City of Albuquerque Stormwater Construction Site Inspection Report

ESC File No.	U13E001	Project Name:	Tract 7 MDS		
NPDES Id. No.		Location:	9601 Broadway Blvd SE		
4/14/2022	Owner	Contractor			
Operator	MDS Investments, LLC	Guzman Construction Solutions			
Contact name & title	Kyle Bodine	Rudy Guzman			
e-mail	Kyle@sc3intl.com	rudy@guzmancs.com			
Contact Phone #	681-9932	505-459-3128			
COA Inspector	Doug Hughes	Start/End Time:	5PM		
Construction Phase:	Excavation/grading				
Type of Inspection:	<input type="checkbox"/> Regular	<input type="checkbox"/> Storm Event	<input type="checkbox"/> Past Storm Event >0.25"	<input type="checkbox"/> 311/Complaint	<input checked="" type="checkbox"/> Follow Up
Weather at time of inspection?		Cloudy		Temperature: ~ 75	
Estimated date of last storm 0.25" or greater		3/22/2022

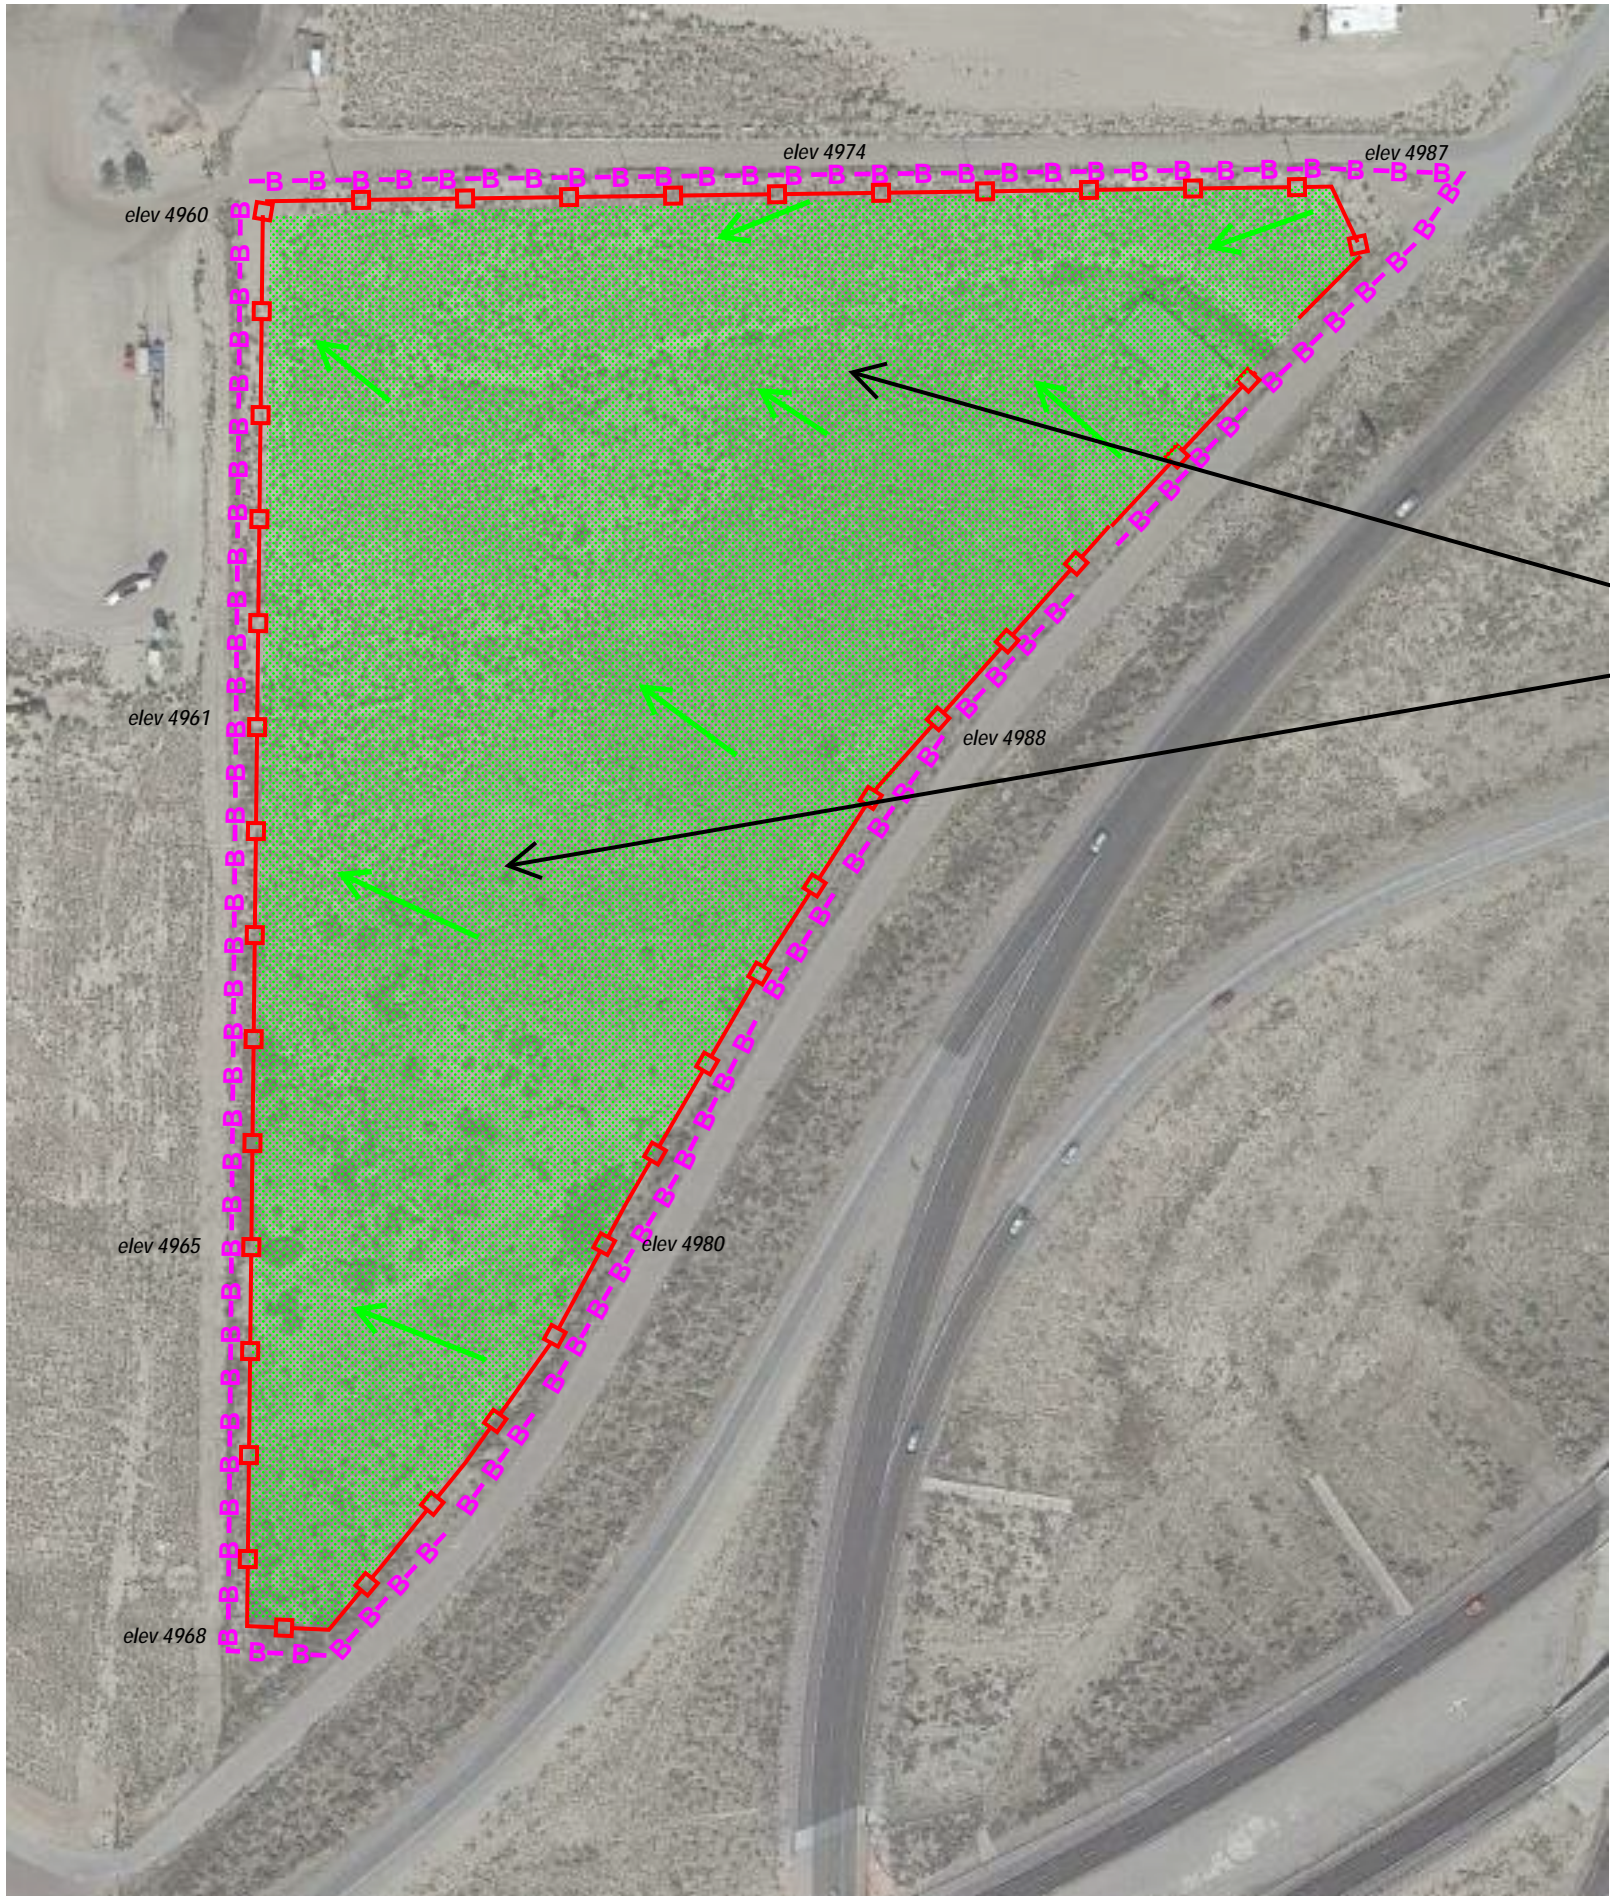
Item Number	Deficiency/ Corrective Action				
1	There hasn't been any noticeable activity in 29 days. Stabilize areas that are to remain inactive for 14 days or more per CGP2.2.14.a. The Arid and Semi-arid Exceptions don't apply this time of the year so Seed & Hydromulch would be appropriate. Alternatively Gravel is frequently used to satisfy the Final Stabilization Criteria for Construction Material Storage Yards.

The Silt Fence was in place around the perimeter though it needed maintenance in some spots
Still just 2 stockpiles.
